**To the Planning Inspectorate.
Deadline 5 Written Representation 3 February 2021. (1 of 5)**

**PINS ref : EA1N 20024031. EA2: 20024032.
These remarks refer to both EA1N and EA2.**

To the Planning Inspectorate.
Deadline 5 Written Representation(2 of 5).
PINS ref: EA1N: 20024031 EA2: 20024032.
These remarks are in respect of both EA1N and EA2.

To the Planning Inspectorate.
Deadline 5 Written Representation , 3 of 5
PINS Ref: EA1N: 20024031 EA2: 20024032.

| Important Hedgerows and Tree Preservation Order Plan Sheet Number: Sheet 2 of 12 | | | Rev | 5 | British National Grid OSGB36 |

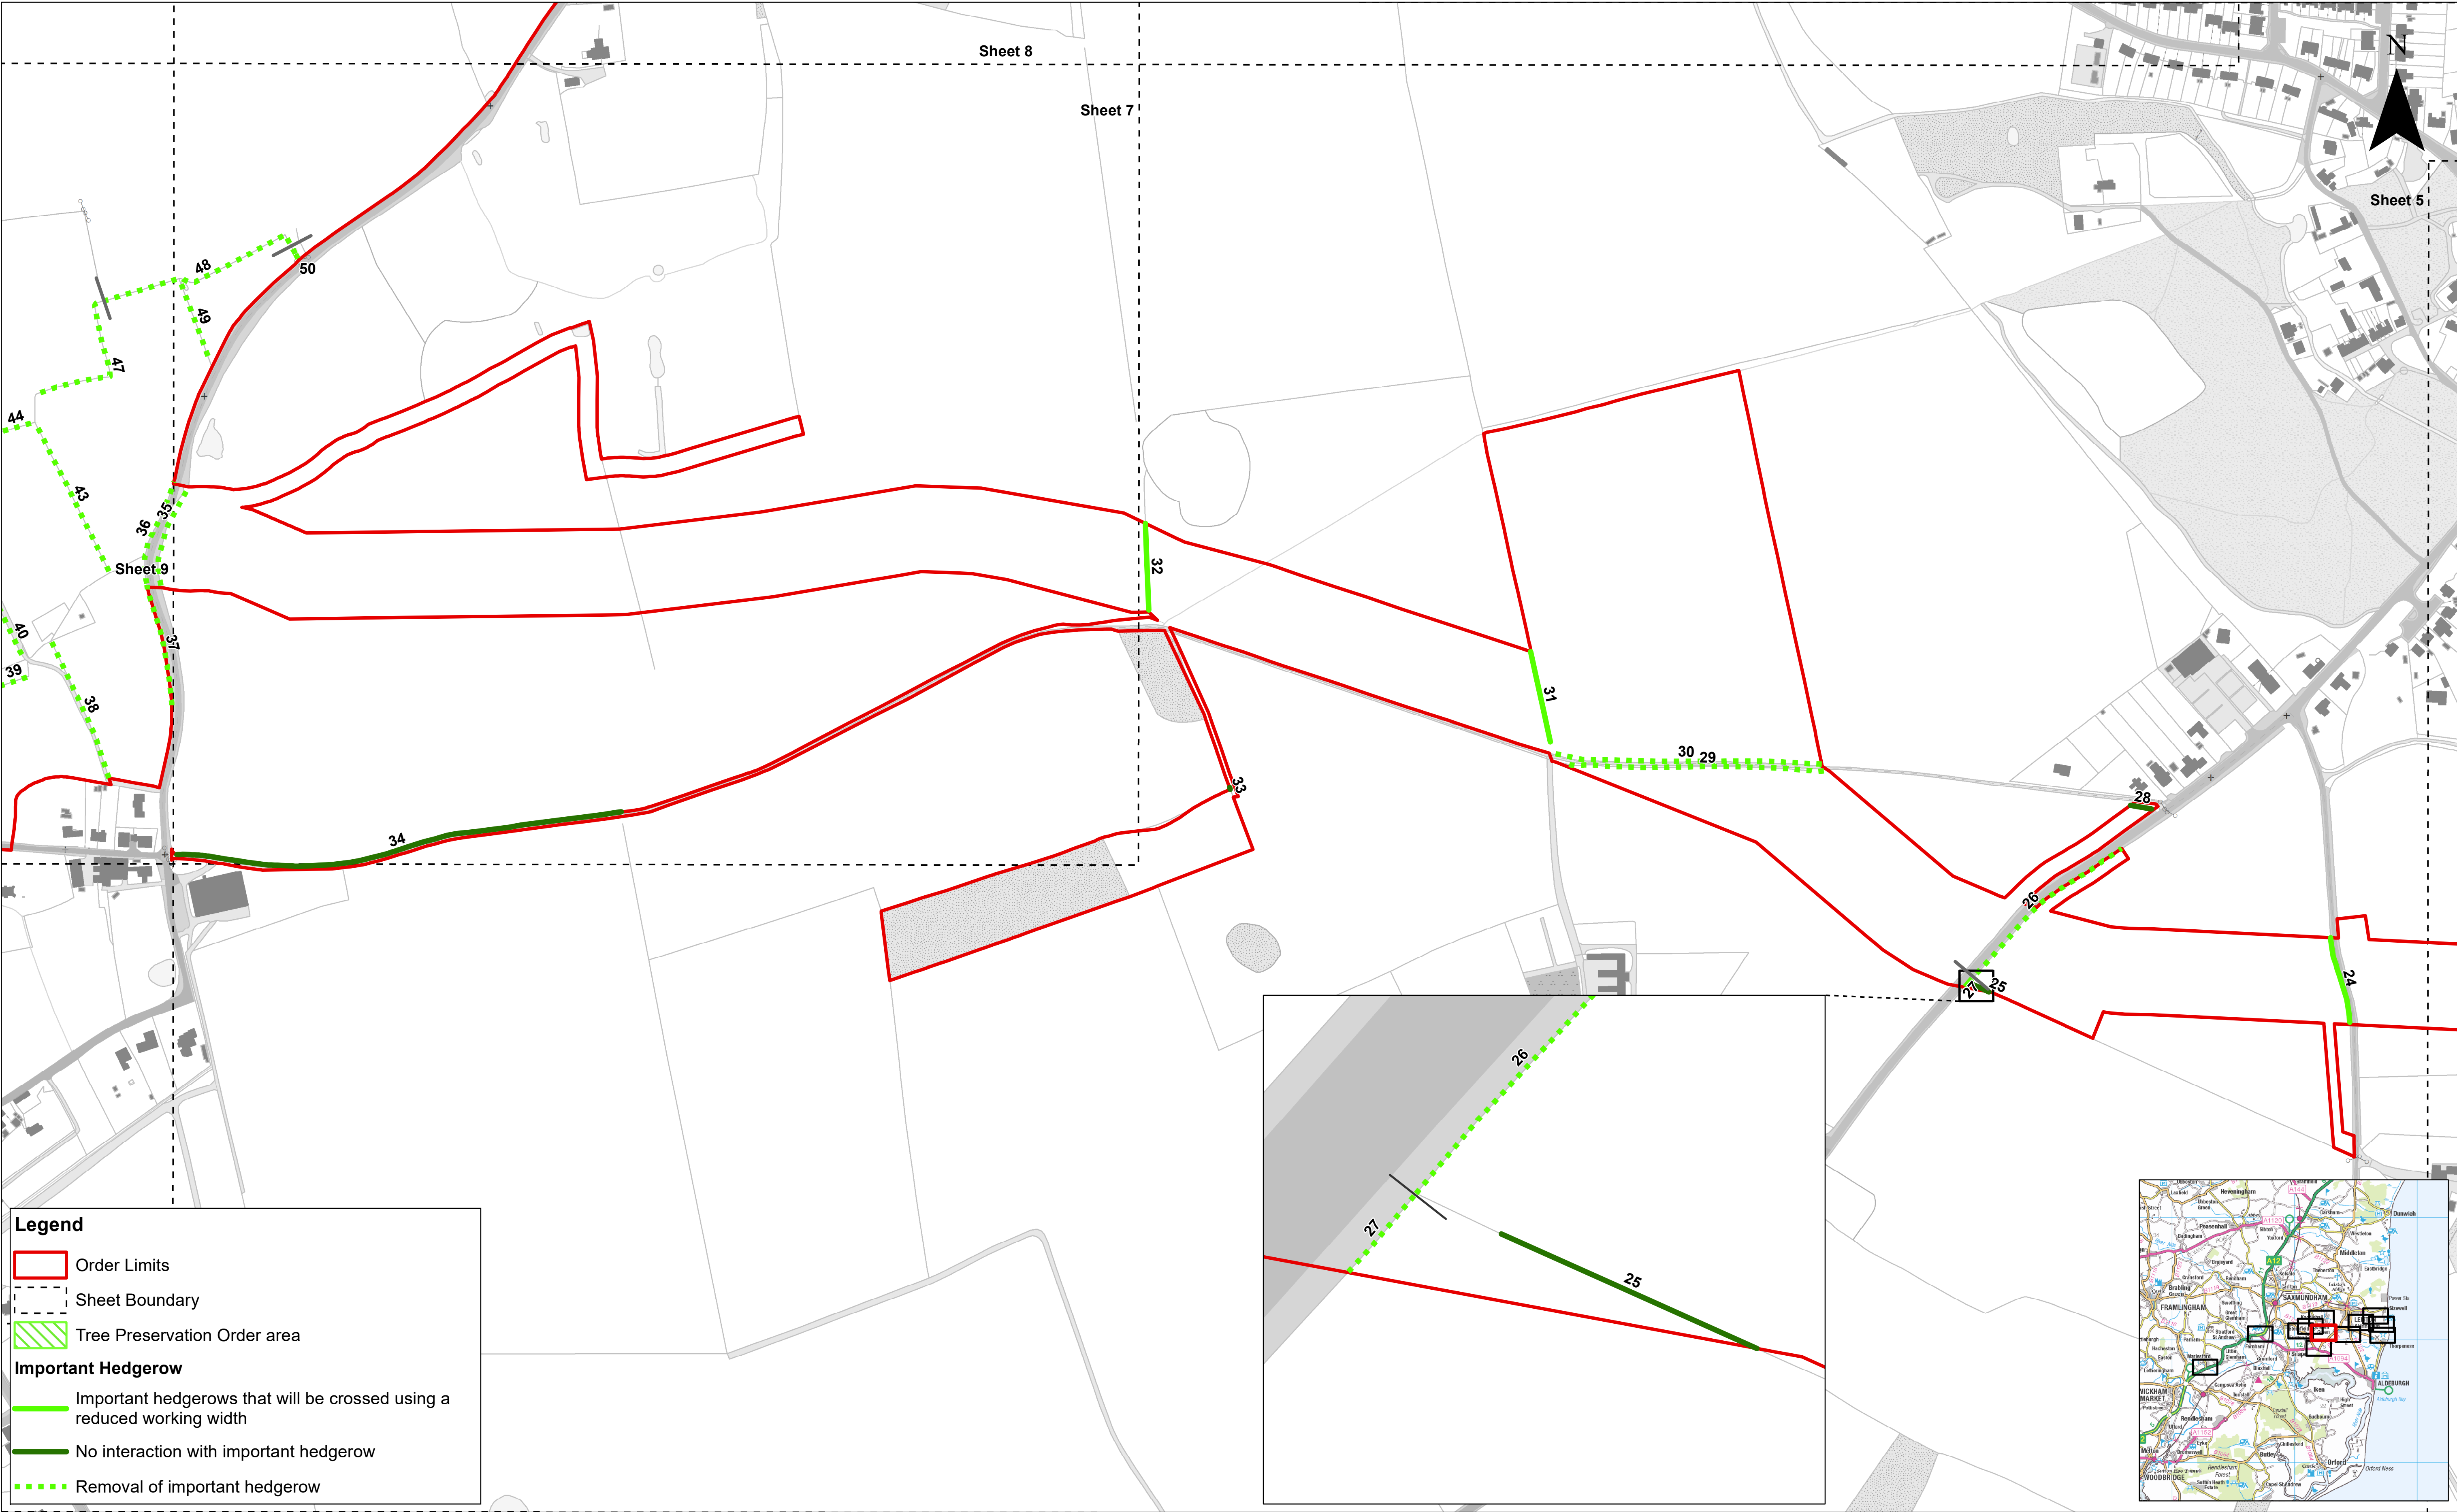
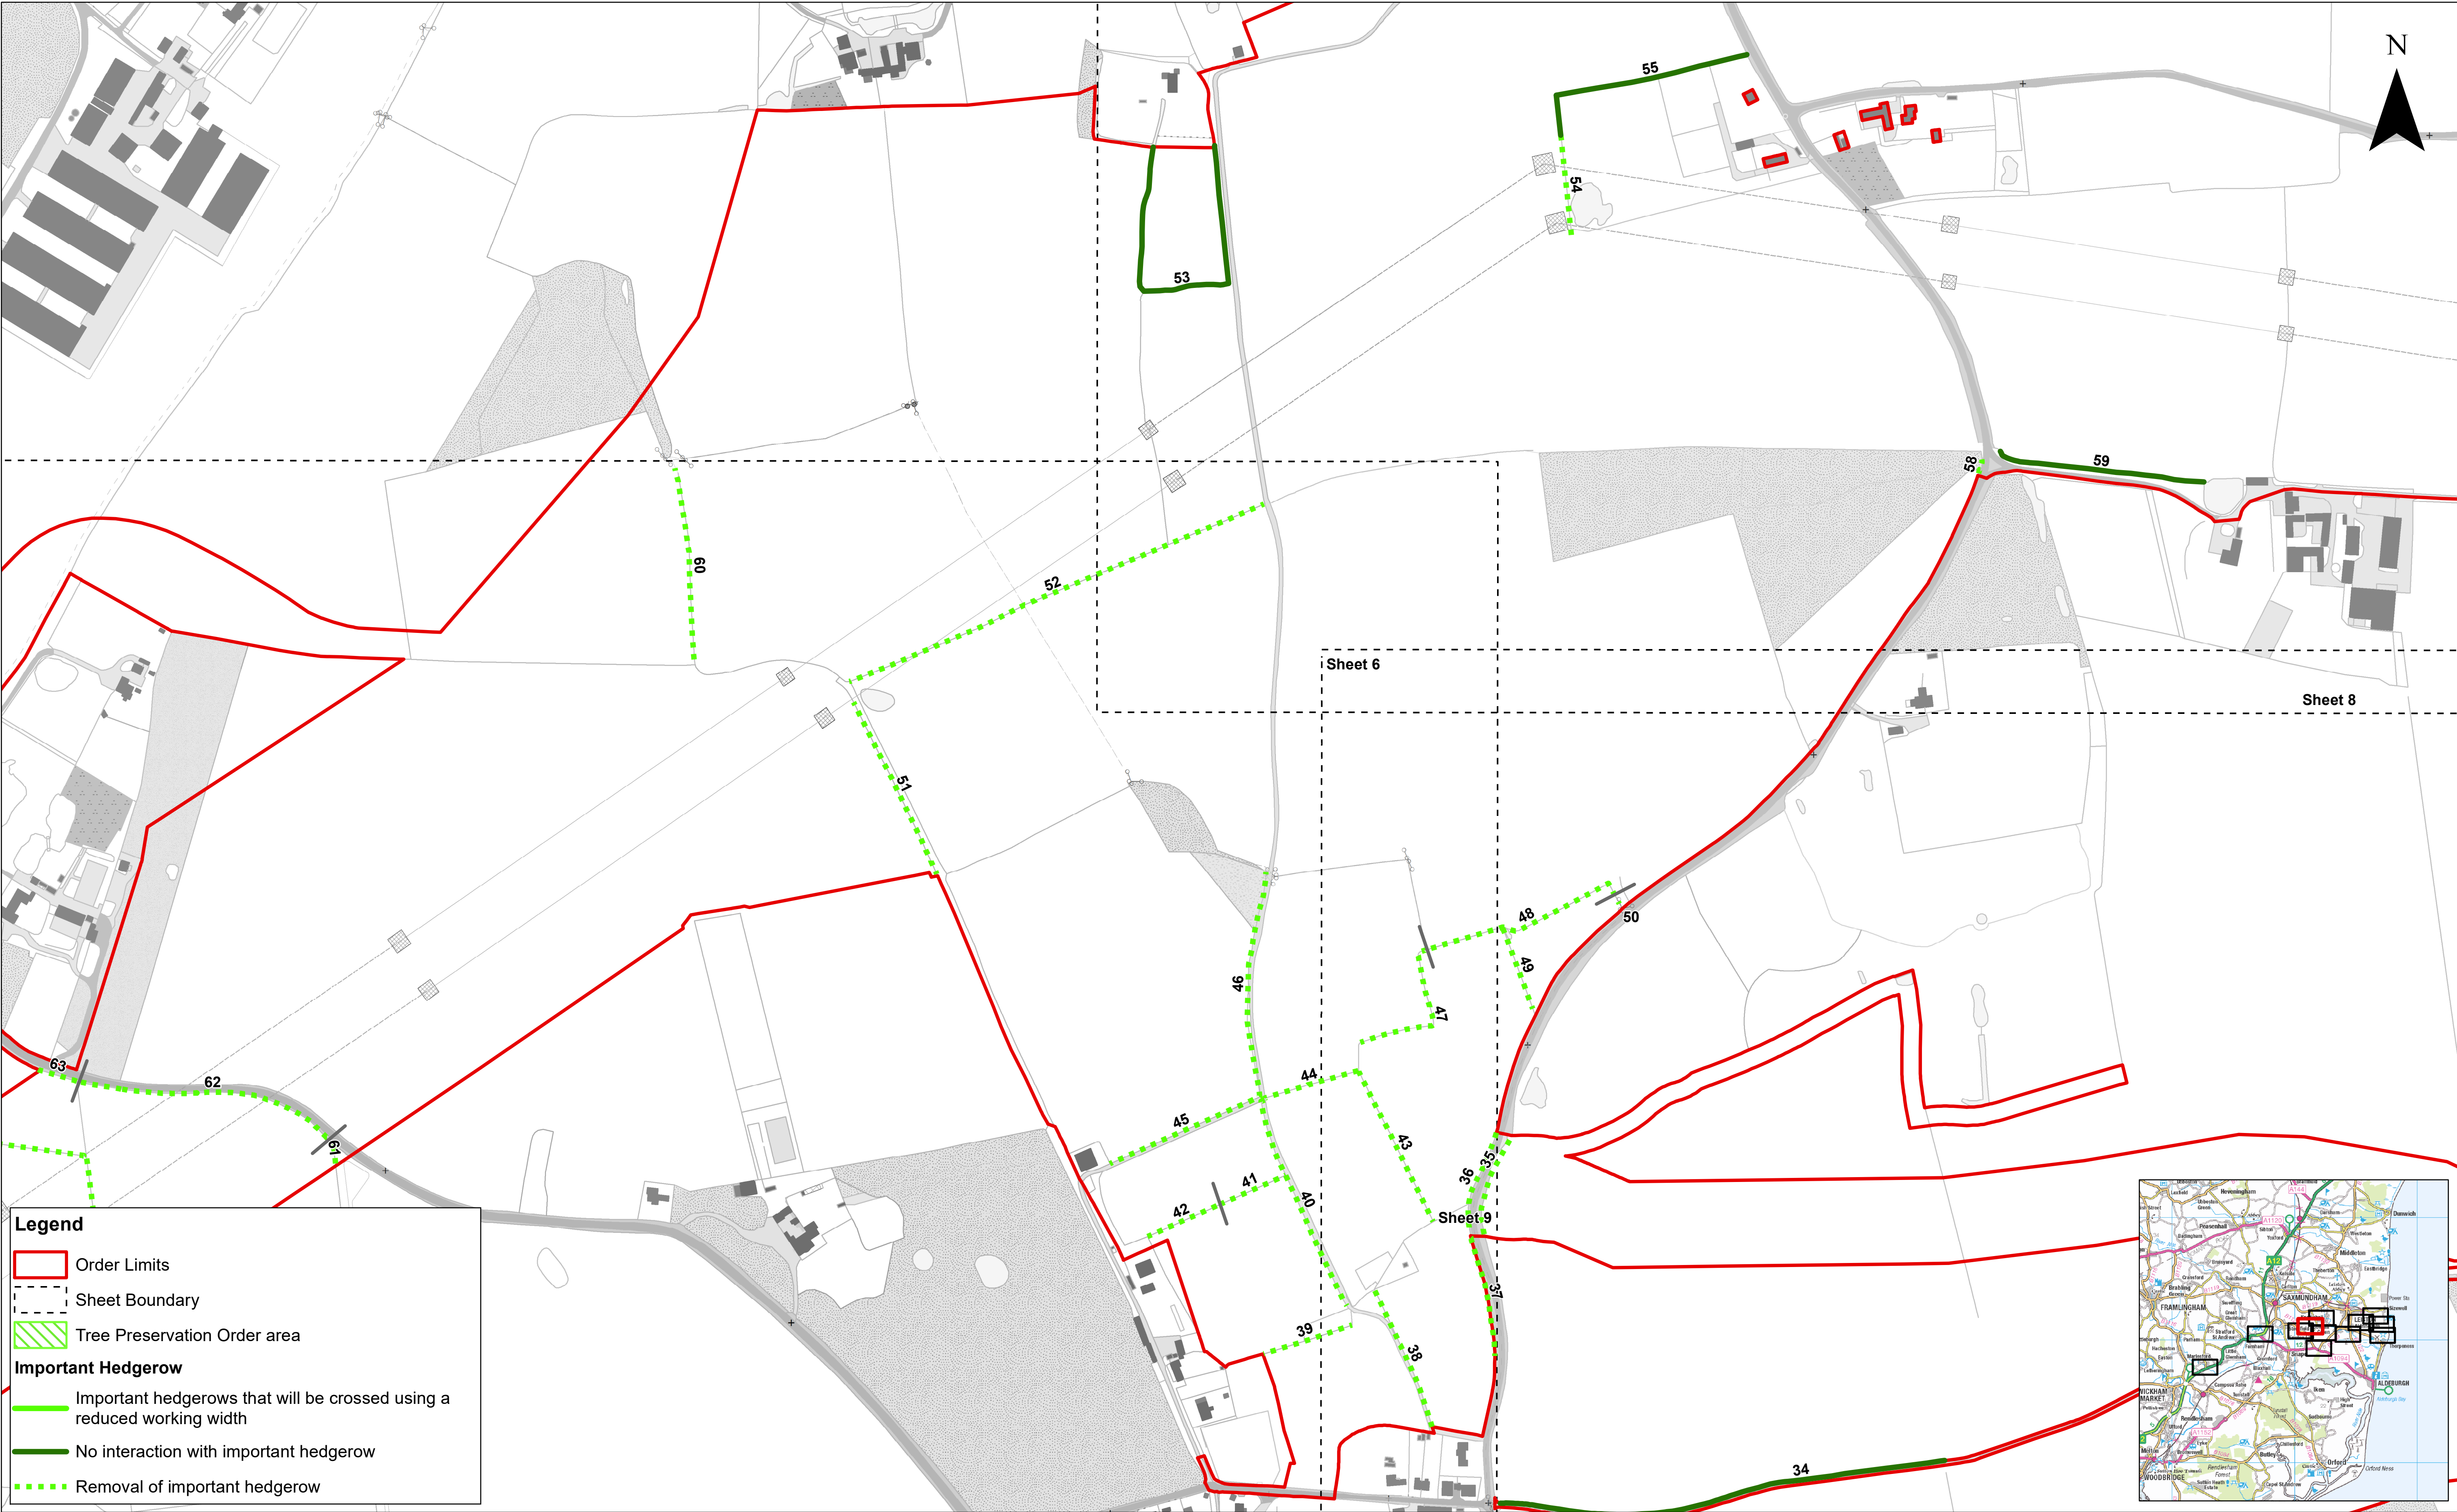
Hedgerow 3, on Sheet 2 will have been walked along by the Panel at their site visit on 27 January, as they walked southwards with the sea and Plot 4 at their left hand side towards Thorpeness Common. In fact it consists largely of very large shrubs and many trees, rather than being recognisable as a hedgerow, on the side adjoining Work 8, and there are also trees and shrubs on the seaward side. I would suggest that these should be identified as two hedgerows, as presumably both will be removed, rather than one. I attach a screenshot of the map **NRMM Emissions Assessment Scenario A, Sheet 1** to identify the location of these hedgerow(s) in relation to the Landfall HDD construction site. The line of growth of Hedgerow 3 is highlighted in green

.....
The destruction of these long established and densely populated hedgerows will not only

cause ecological damage, but will also remove a significant stabilising buffer between Work no. 8 (the Landfall HDD compound) and the dwellings at [REDACTED] and Warden's.

These plantings and vegetation prevent sand storms, and their removal will produce a very large tract of land subject to erosion and the loss of an important . It would also remove some noise and pollution mitigation for the residents near [REDACTED] and Warden's. The hedgerows will take many years to re- establish, if ever, to the same state. Much reference has been made throughout this Examination to the difficulty of growing trees and the very long time periods involved in this local area, particularly here where the ground is mainly sand.

Hedgerow 4 on the same map, **Sheet 2, (APP-020)** adjoins a point on the access to Warden's(an access which may or may not remain usable by us, depending upon the success of the Applicants negotiations with the neighbouring landowner. I refer to this in more detail in my Deadline 5 submission, Socio- Economic effects). This vegetation also forms an important wind and dust break, as well as being a valuable refuge for deer as they approach the salty vegetation nearer the sea and a rich habitat for wildlife.

If these important hedgerows are to be removed, I would like to see the severance of hedgerows limited at these locations according to the Applicants own undertaking. (Statement of Common Ground with East Suffolk Council and Suffolk County Council LA 02.24).
